From: Julie Grieves on behalf of Planning.Responses
Sent: 26 October 2017 10:01
To: Planning Scanning
Subject: FW: Planning Consultation on: AL/118/17/HH
Attachments: Drainage - Supplementary Guidance Notes.pdf

APPLICATION AL/118/17/HH

Site Address: Northfields Hook Lane Aldinbourne PO20 3TE

Description of Works: Part two storey rear extension, single storey rear extension & first storey side extension.

Drawing 4 / 4

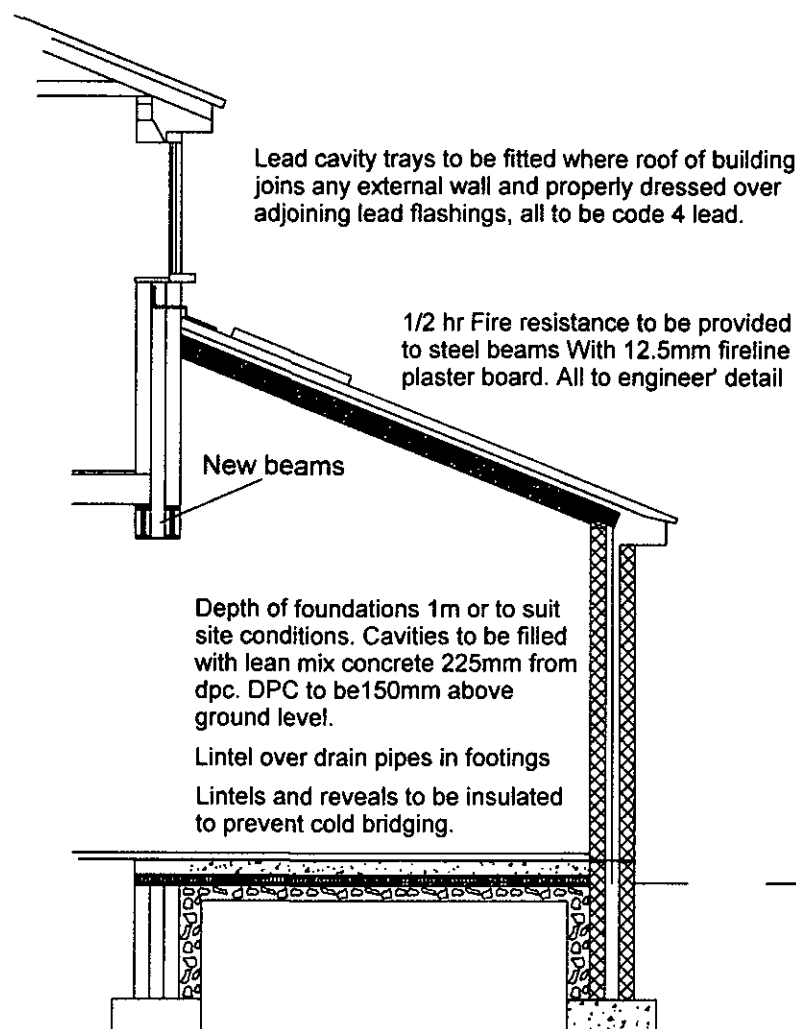
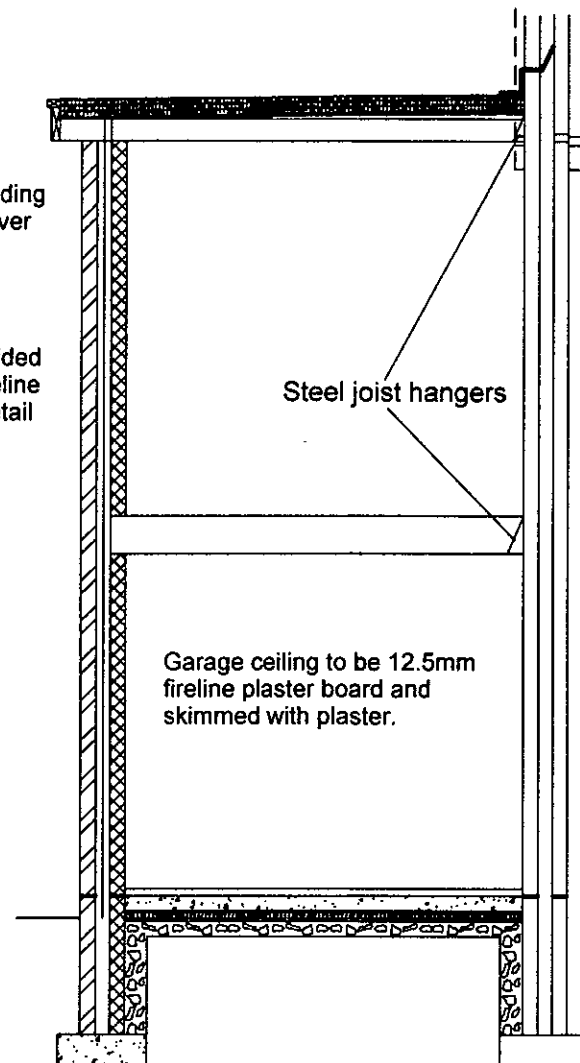
Soakaways must be investigated for surface water disposal, as mentioned in the application.

Infiltration rates for soakage structures are to be based on percolation tests undertaken in the winter period and at the location and depth of the proposed structures. The percolation tests must be carried out in accordance with BRE 365, CIRIA R156 or a similar approved method and cater for the 1 in 10 year storm between the invert of the entry pipe to the soakaway, and the base of the structure. It must also have provision to ensure that there is capacity in the system to contain below ground level the 1 in 100 year event plus 30% on stored volumes, as an allowance for climate change. Adequate freeboard must be provided between the base of the soakaway structure and the highest recorded annual groundwater level identified in that location.

Any SuDS or soakaway design must include adequate groundwater monitoring data to determine the highest winter groundwater table in support of the design. The applicant is advised to discuss the extent of groundwater monitoring with the Council's Engineers. Supplementary guidance notes are also enclosed for information.
